From: Amanda Scholes on behalf of Planning.Responses
Sent: 09 August 2017 08:46
To: Planning Scanning
Subject: FW: BE/71/17/PL - Wickes, Bognor Drainage Scheme

Further Drainage Comments

From: Paul Cann
Sent: 08 August 2017 14:14
To: 'Tim Rainbird'; Simon Davis
Cc: Tom Woolner
Subject: RE: BE/71/17/PL - Wickes, Bognor Drainage Scheme

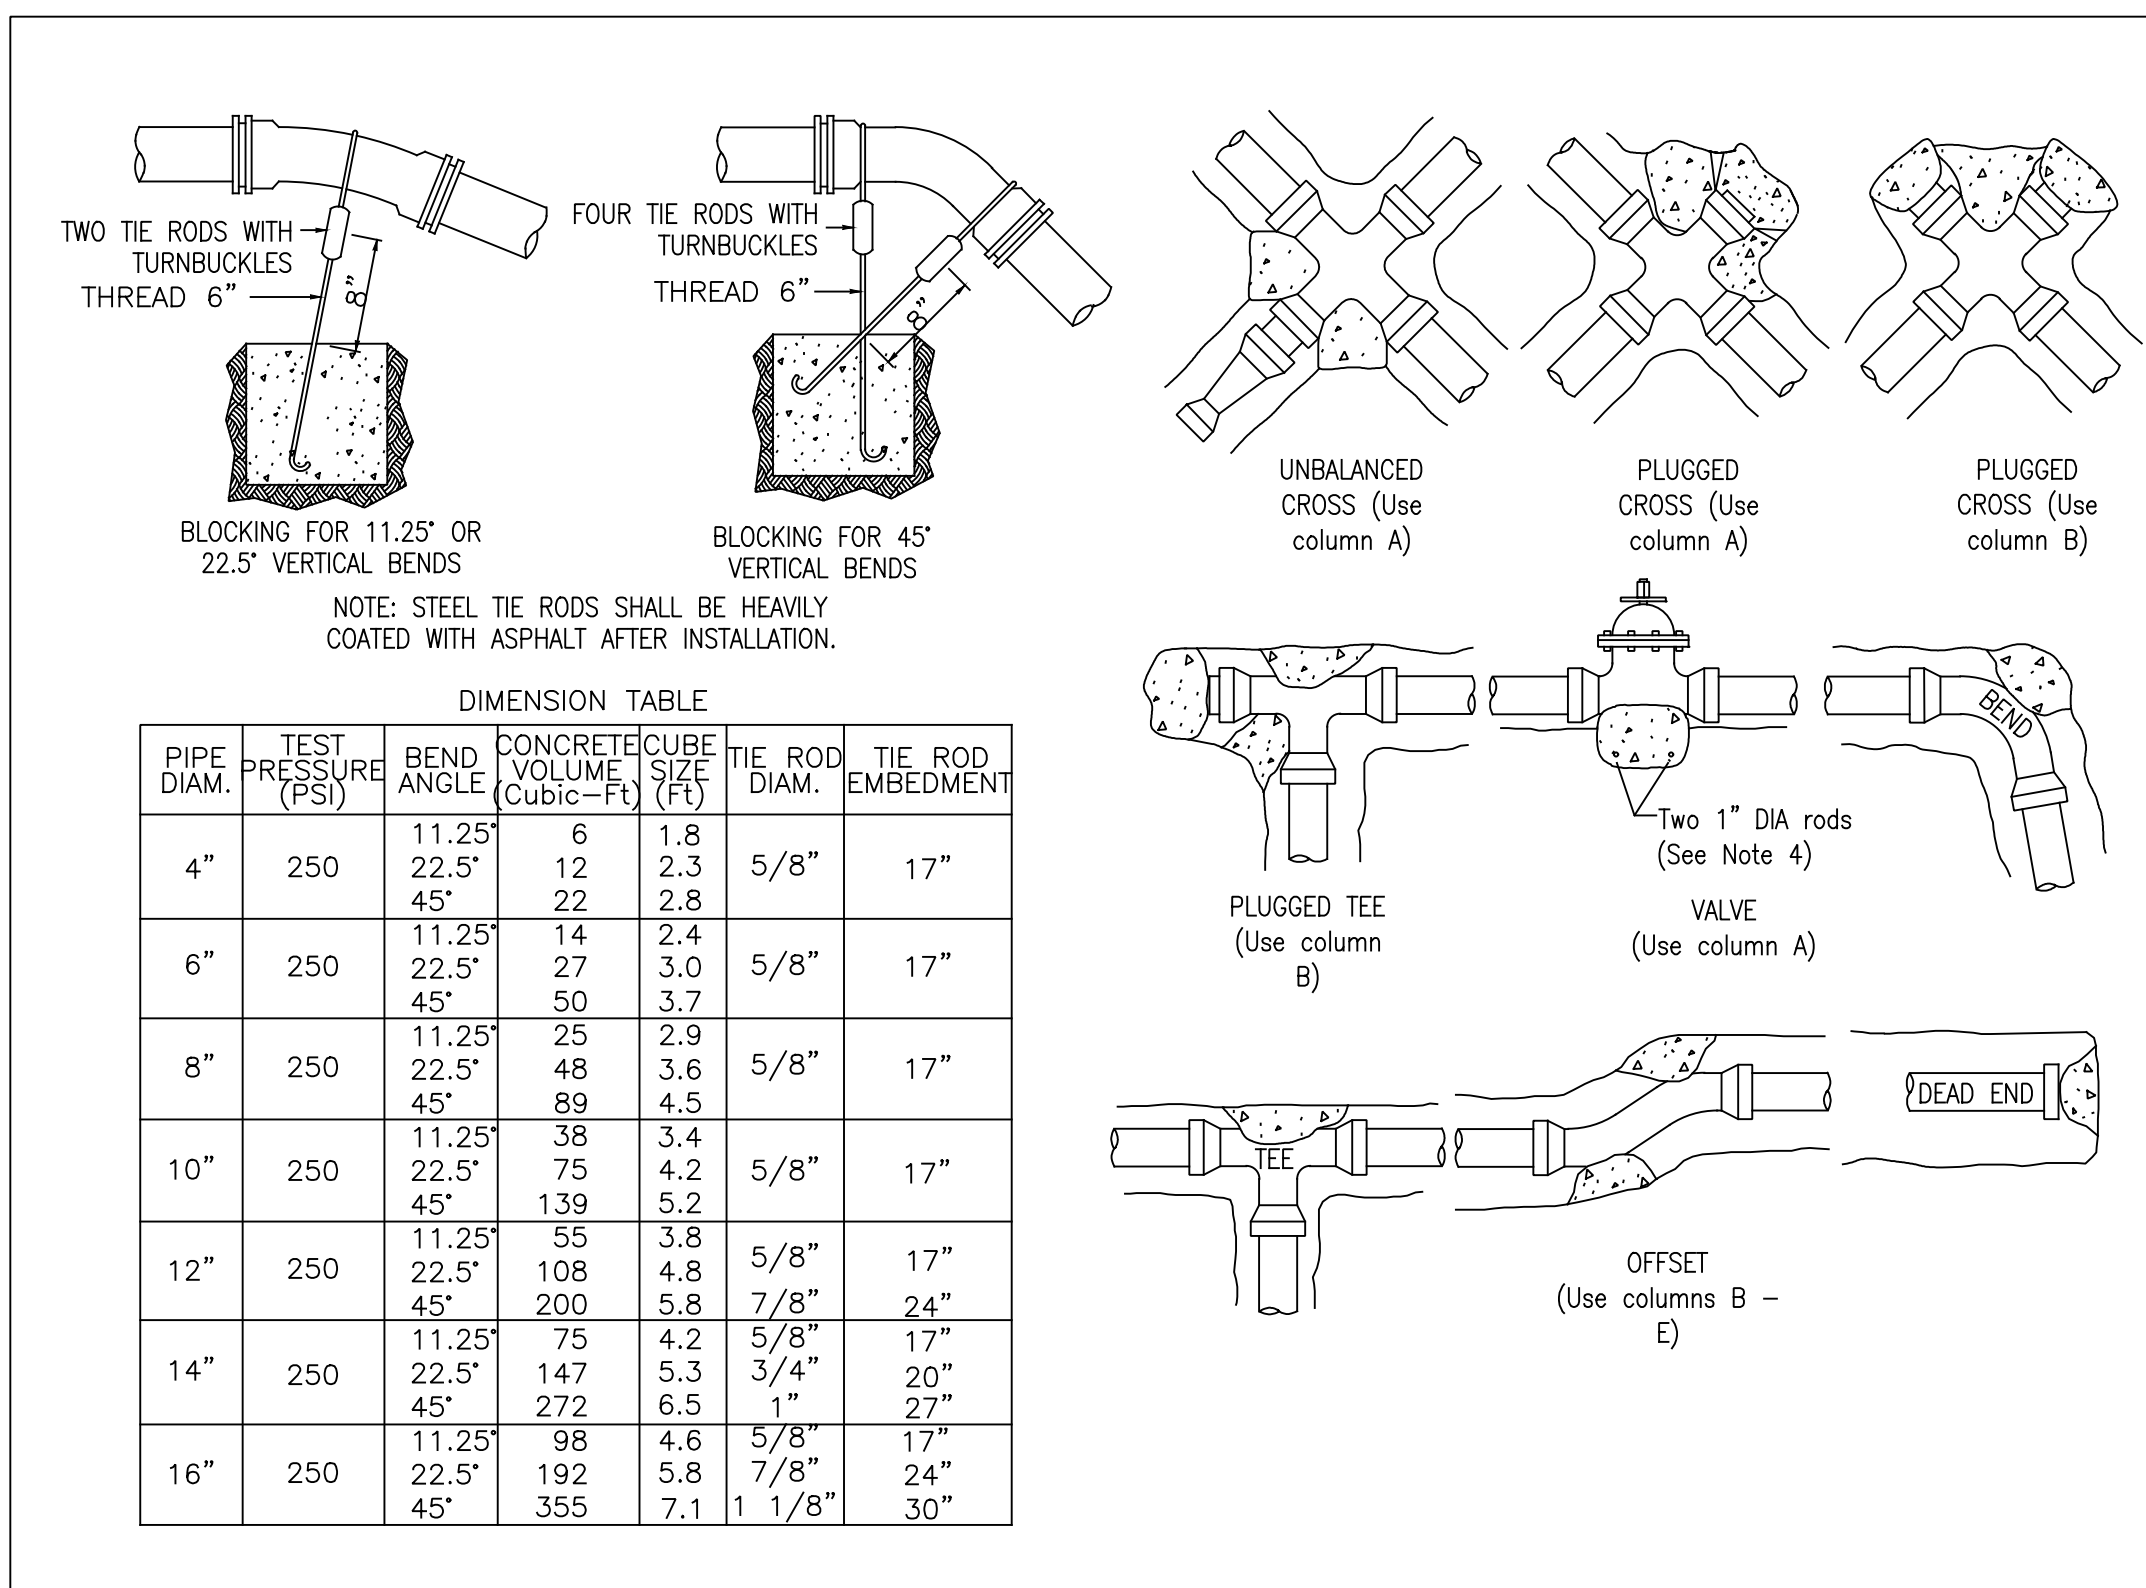
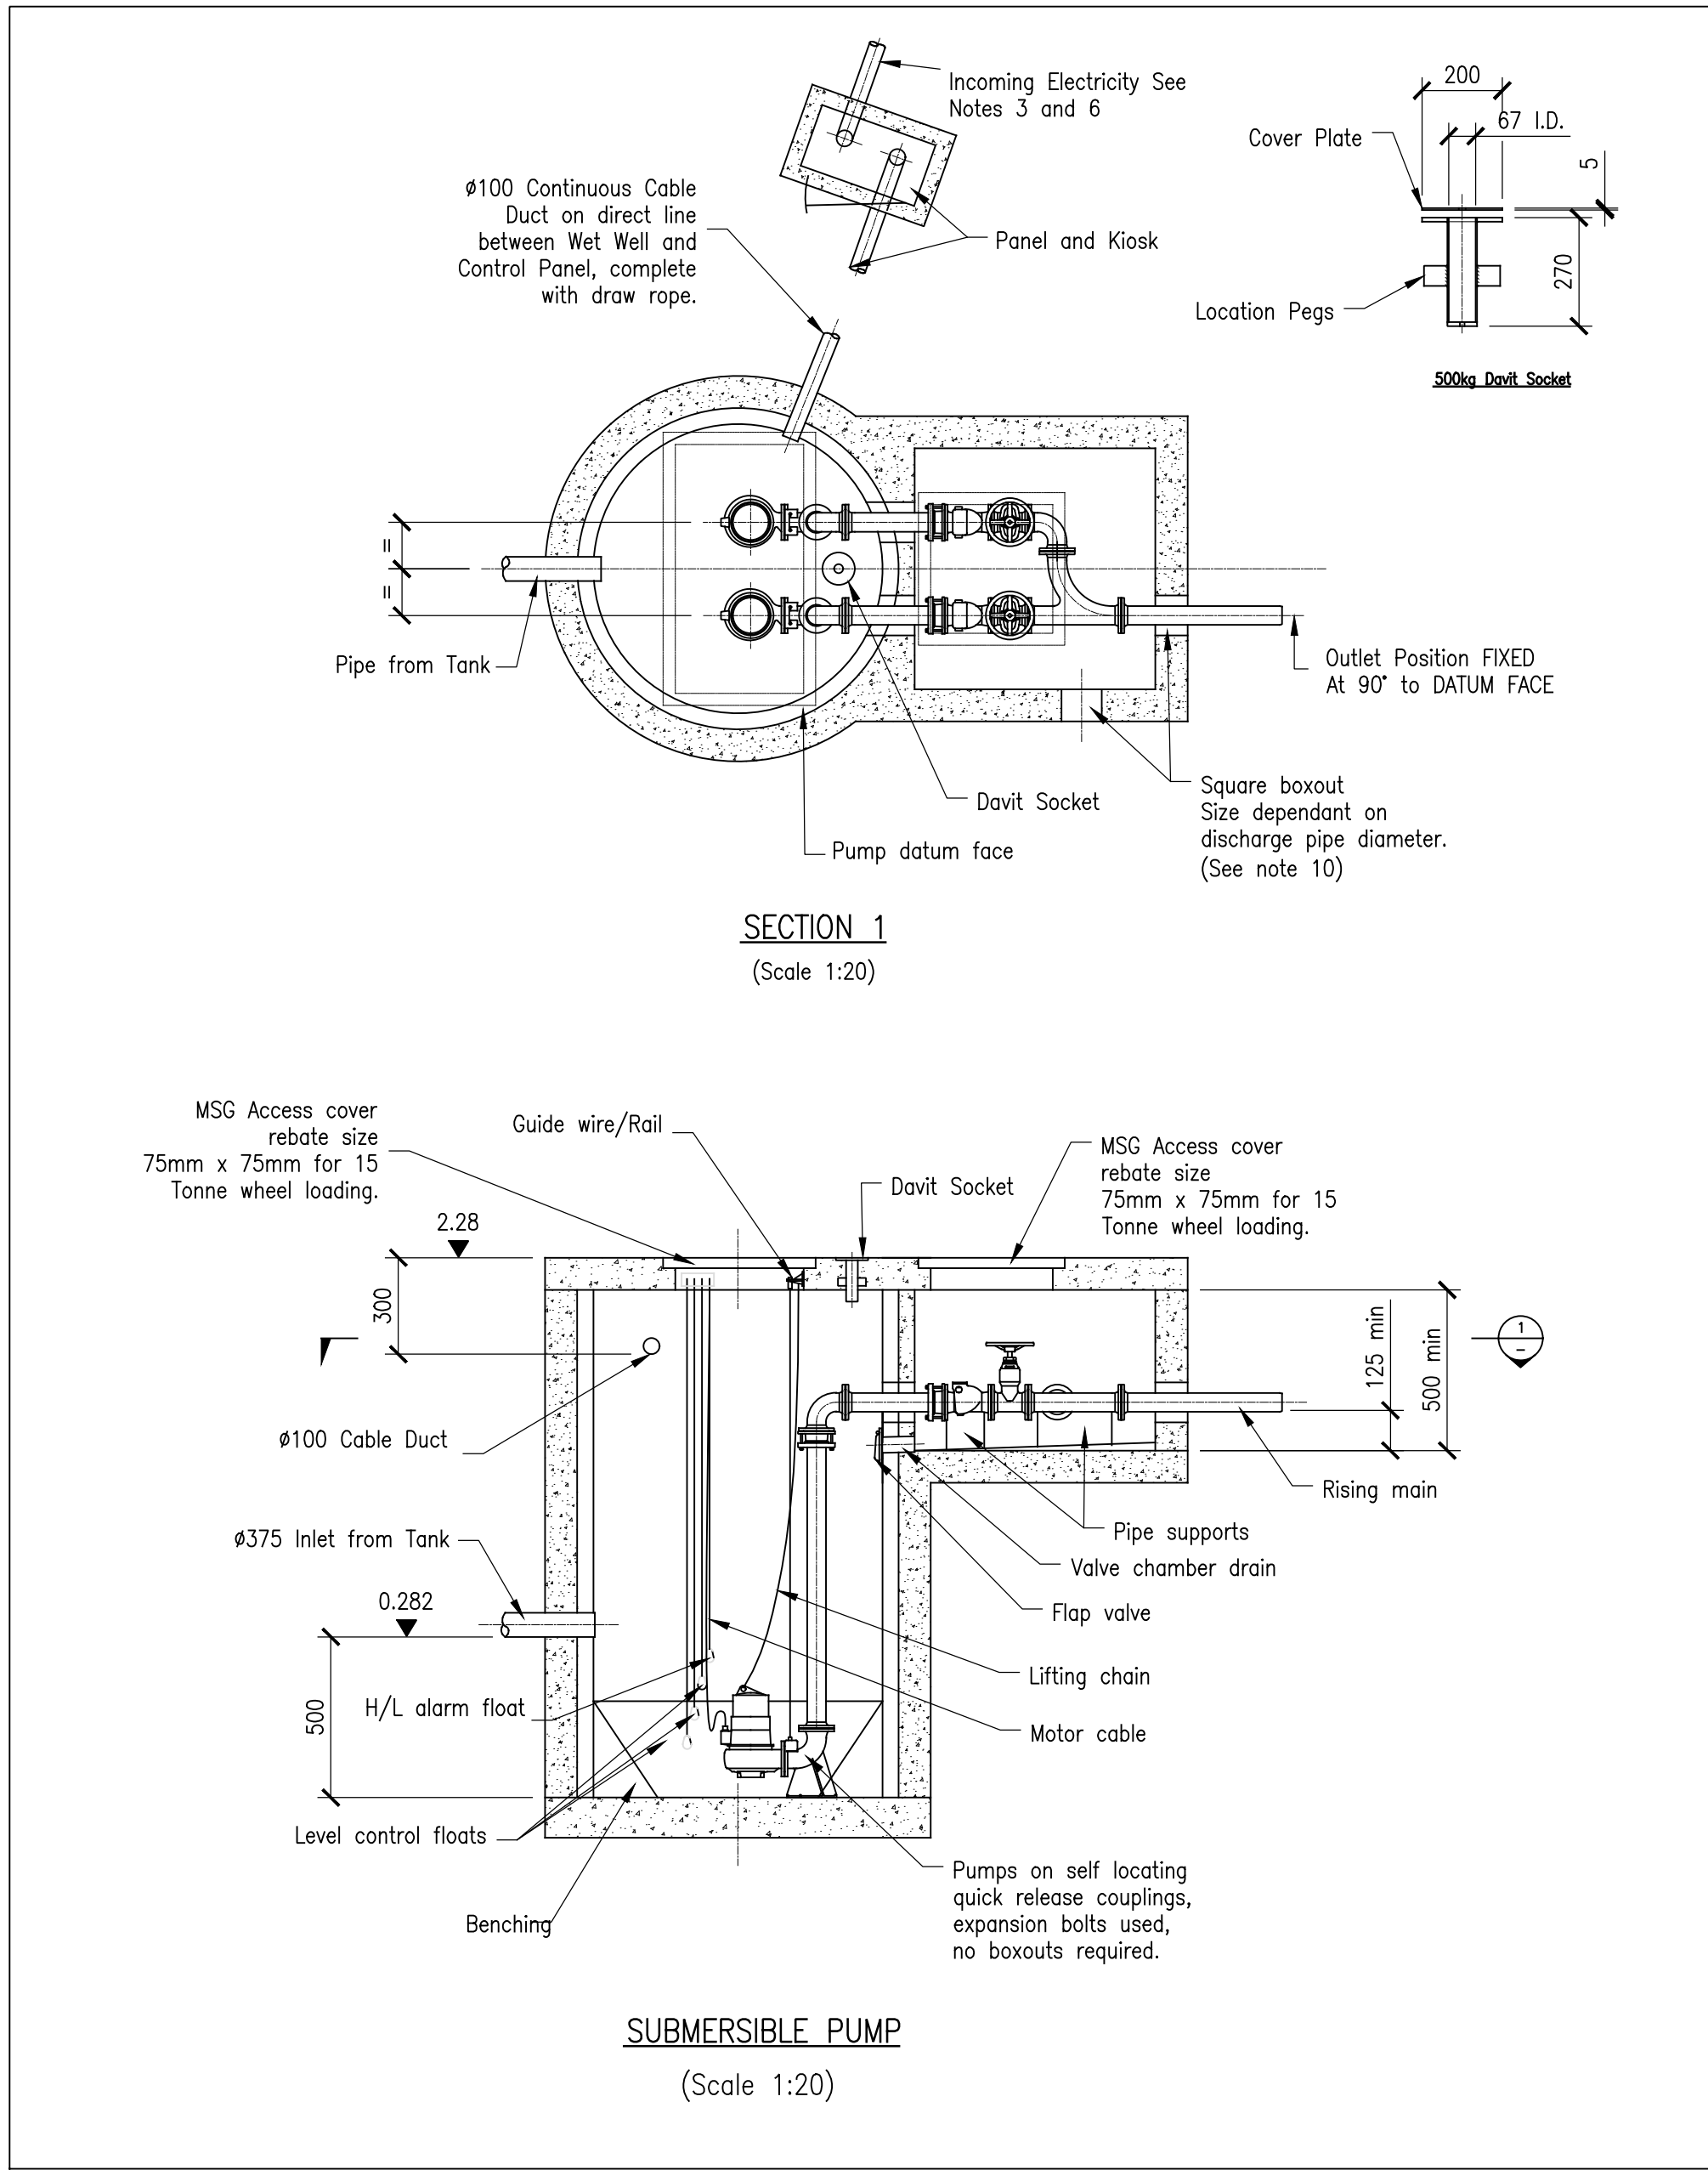
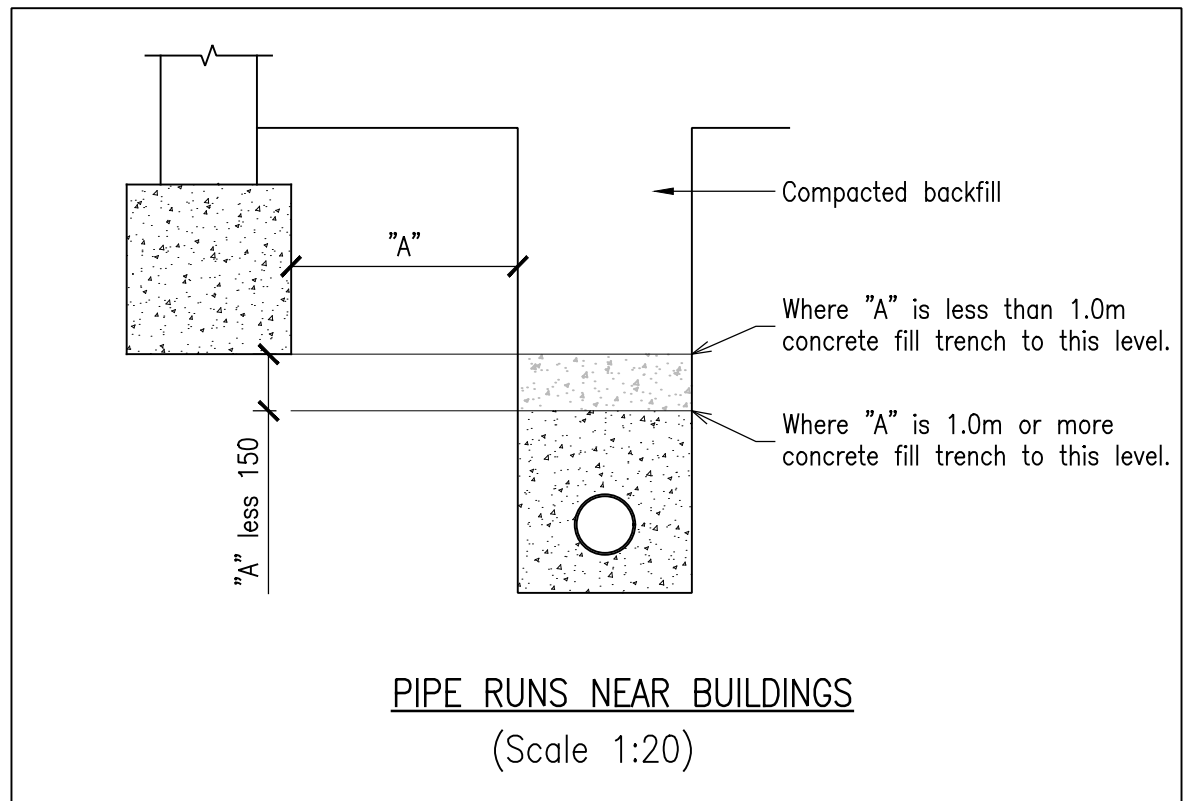
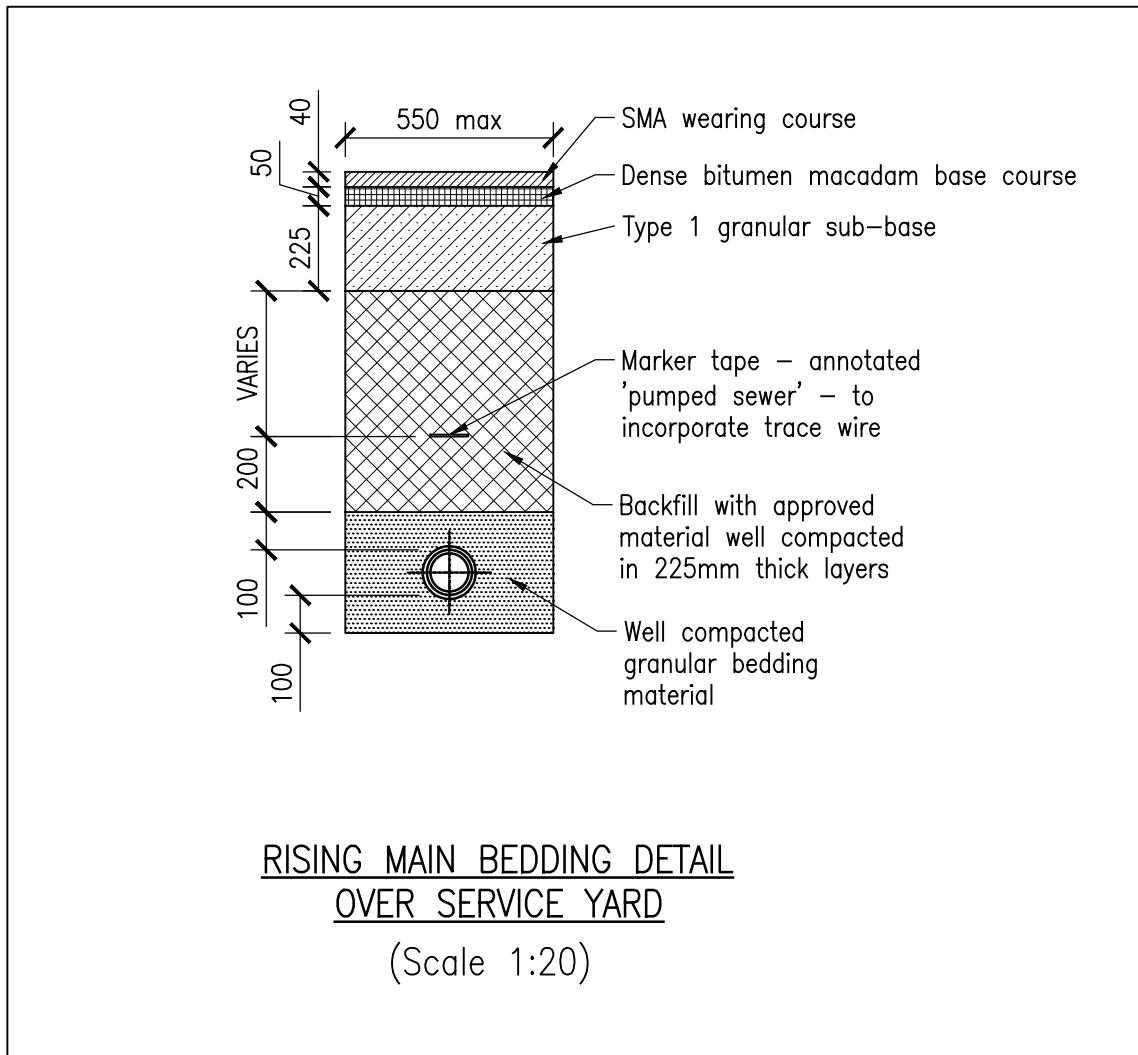
1. Full construction details of the pumping station and rising main. This will also need to include pipe bedding details, thrust block details and discharge chamber details.

5. It is important that the pipework configuration is considered carefully within the discharge chamber to ensure the smooth transition of flows. This will need to be detailed.

Typical details are on the attached drawing 15-112/500

The current discharge point is labelled as manhole S9 on the attached 'as built' drawing from the adjacent Sainsburys development. Specific details of this chamber is unknown although those of upstream chambers S10.1 and S10 are. Hence levels will be confirmed to the pump supplier when the contractor orders the pump.
